From: Laura Tyler
Sent: 02 February 2021 12:05
To: Louise Willis
Subject: 21/00007/FUL 43 Nettlecombe

Drawing Status <b>For Approval</b>	Drawing No. <b>001</b>	Rev
---------------------------------------	---------------------------	-----

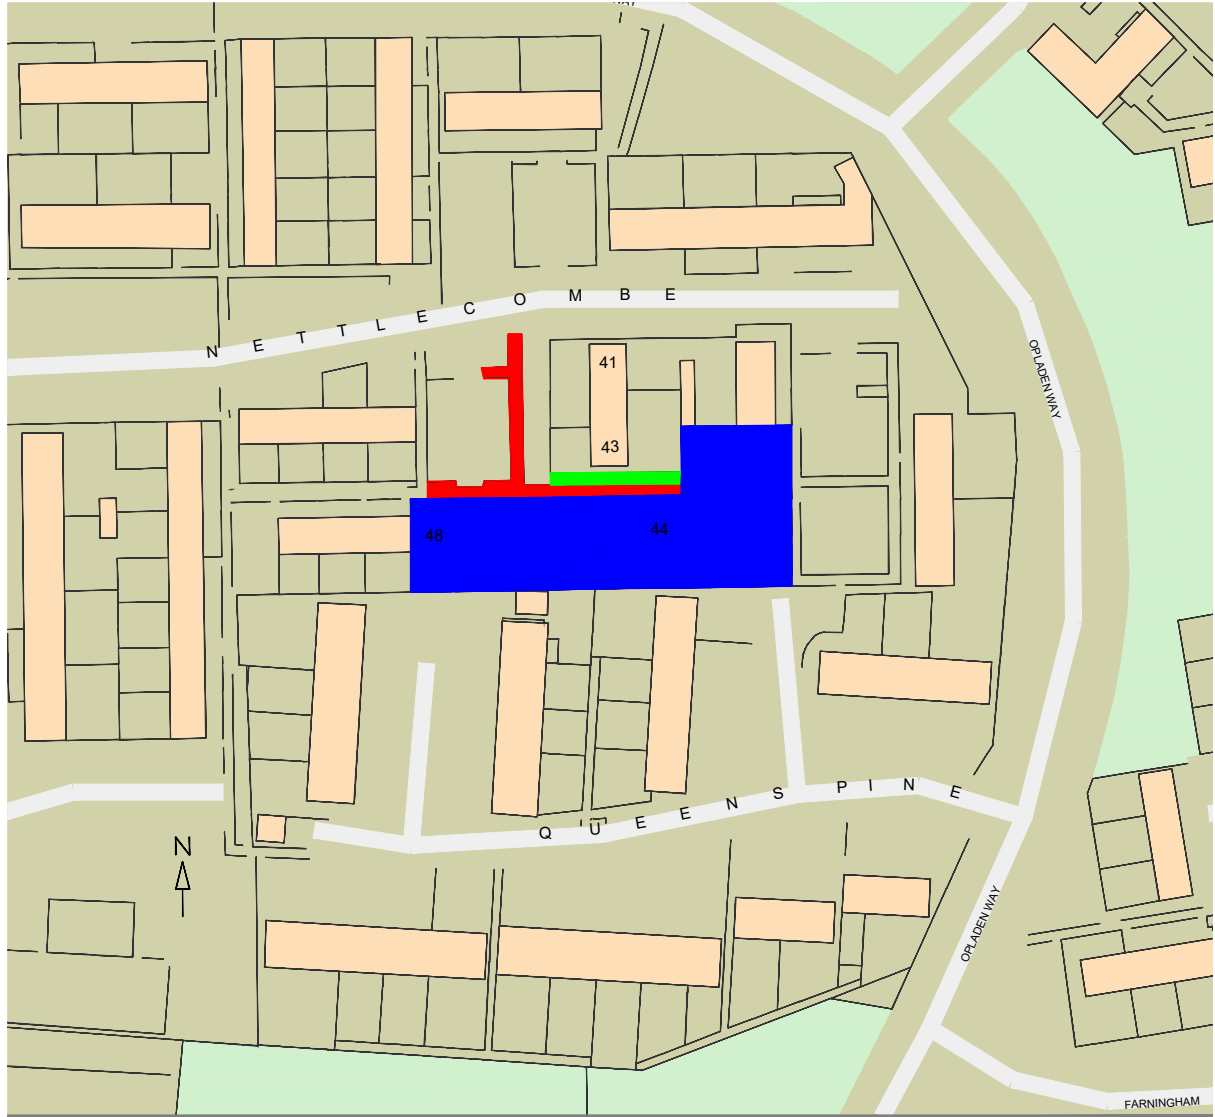
Having sent the plans to the planning officer, they have requested some more information.

Please can you provide a plan that shows the exact position of the proposed fence and further information, either via pictures or drawings and elevations, of the type of fence and posts proposed.
